Hearing Transcript

Project:	Meridian Solar Farm
Hearing:	Transcript of Issue Specific Hearing 1 (ISH1) – Part 2
Date:	9 September 2026

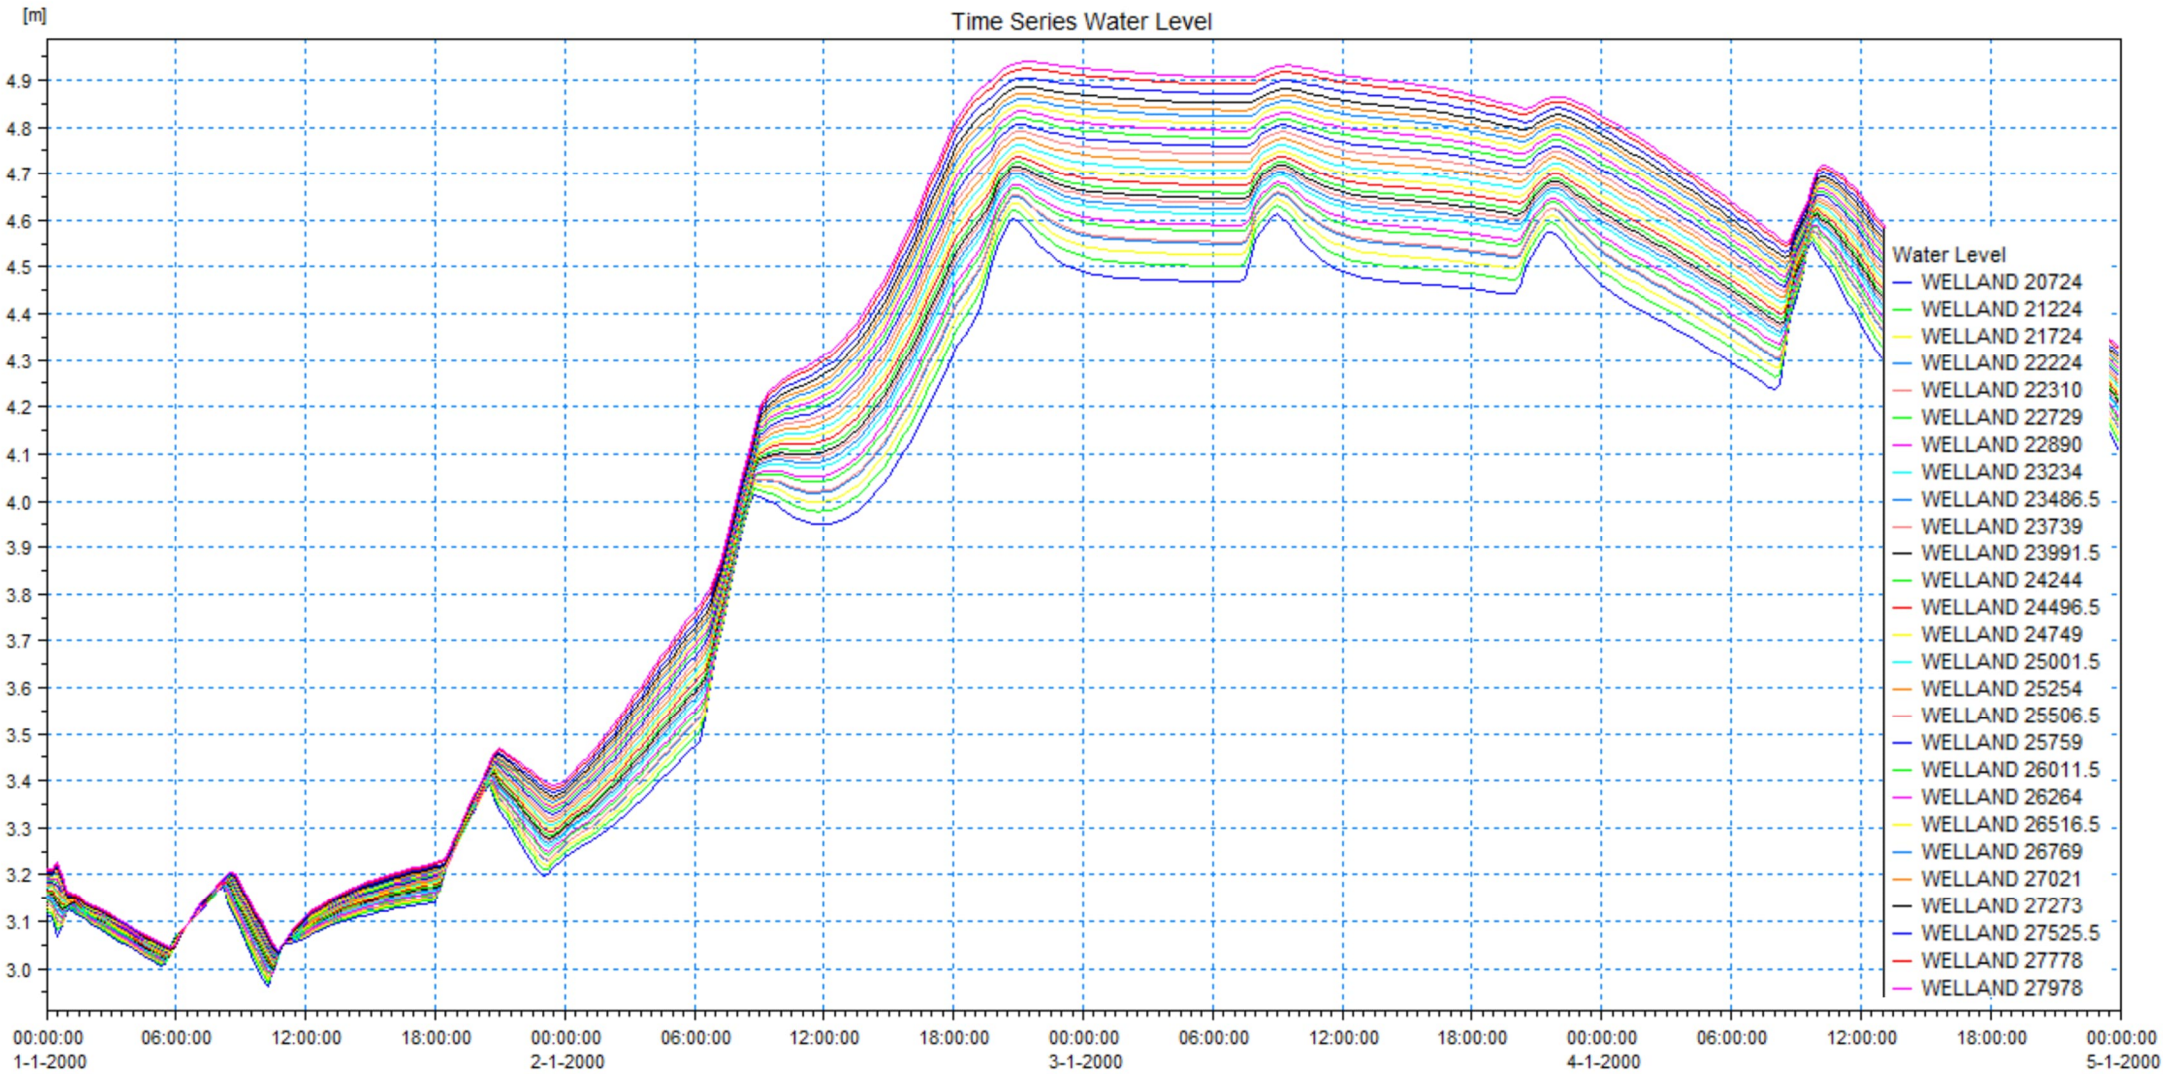
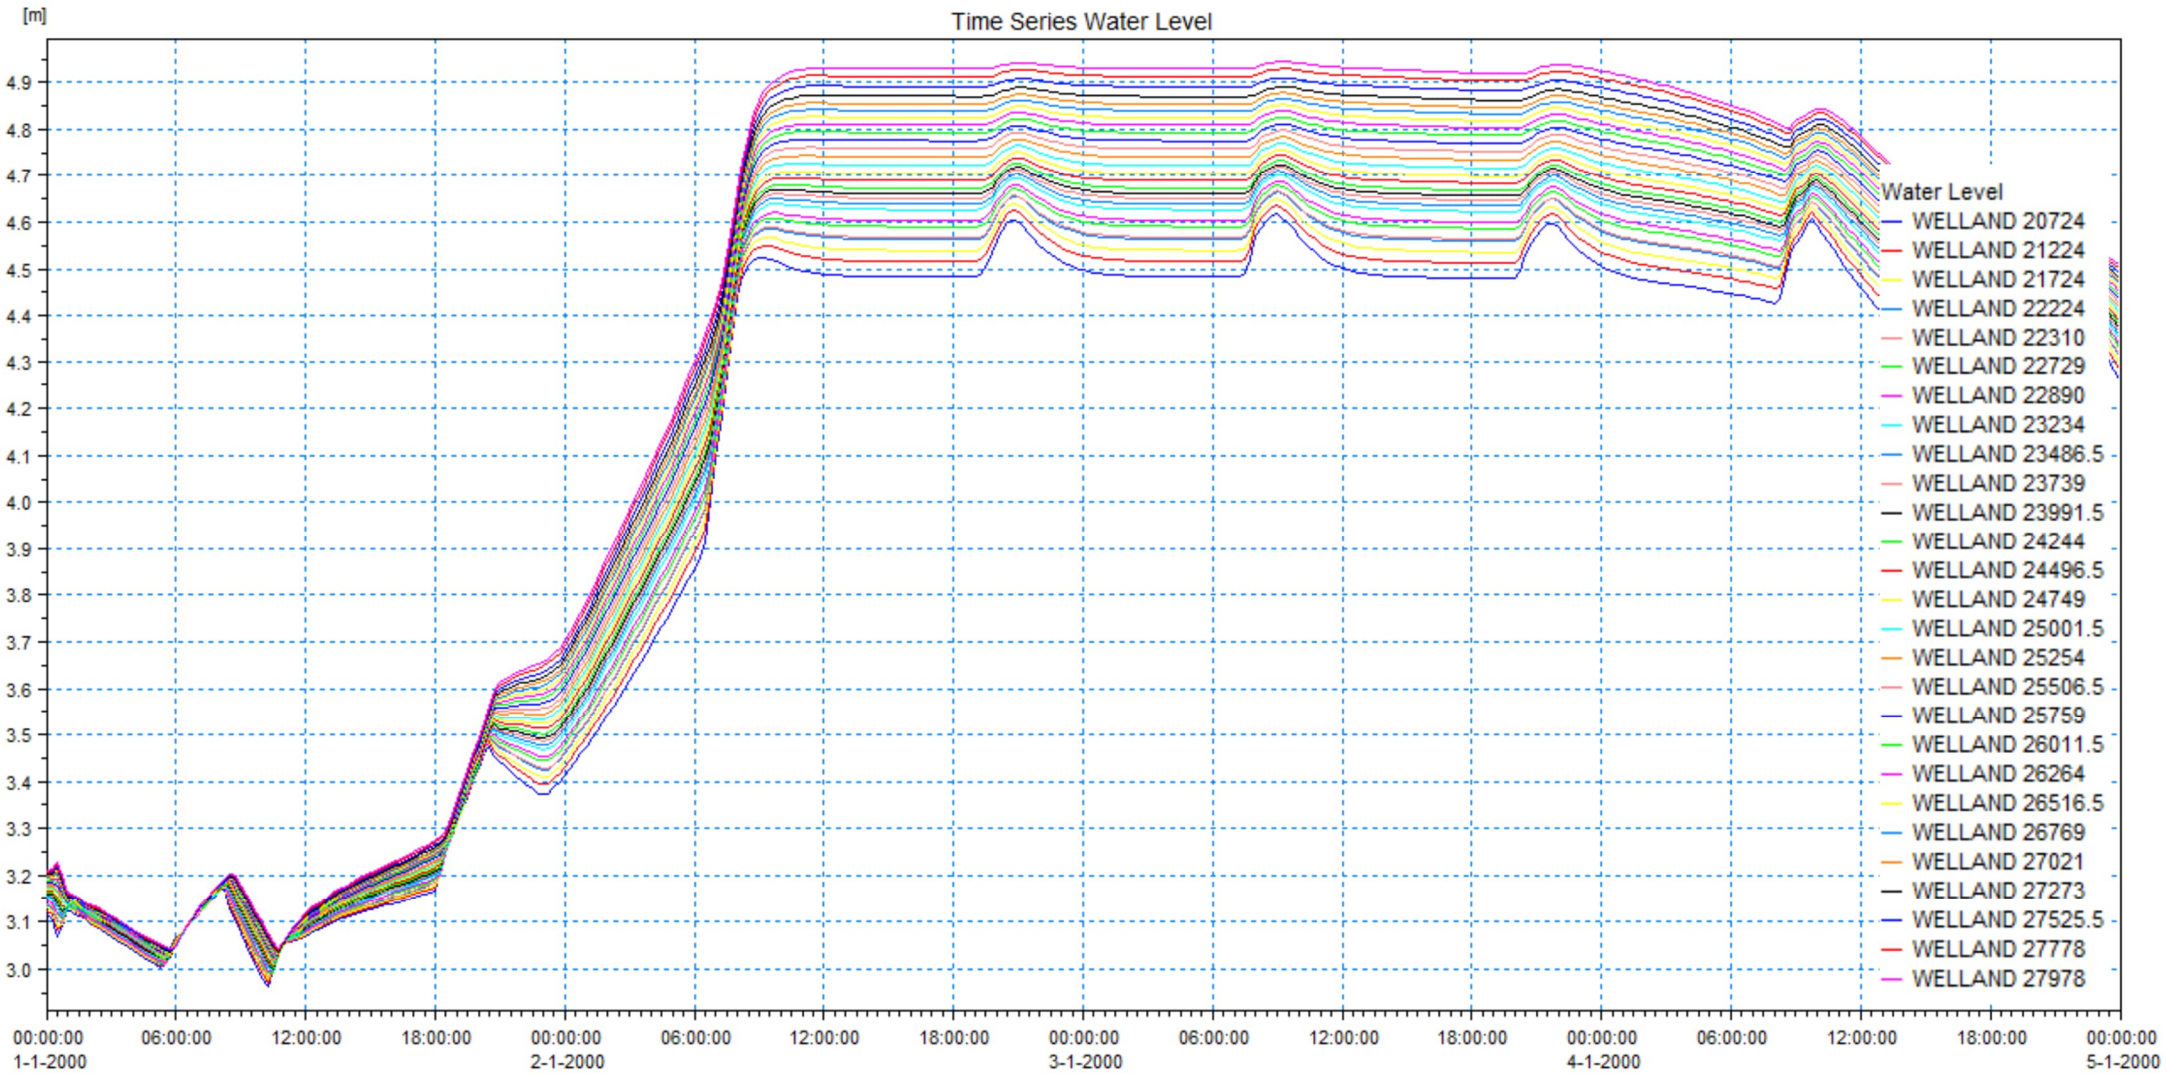
Annex B of Appendix 113,

the applicant has said that they're only going to use the

1% AEP

for the risk modeling for the River Welland rather than

0.1%.

I understand it on the basis that it's

defended and that those are unlikely to

breach during the period of construction.

Is that something that the Environment Agency has agreed to?

flood defenses, including the Crowland and Cowbit Washes.

the flood defenses don't actually overtop in events up to

and including the

0.1%, so one in a thousand year flood, plus climate change.

So yeah, we've agreed that there isn't a defended

flood risk to the proposed development from the Welland itself.
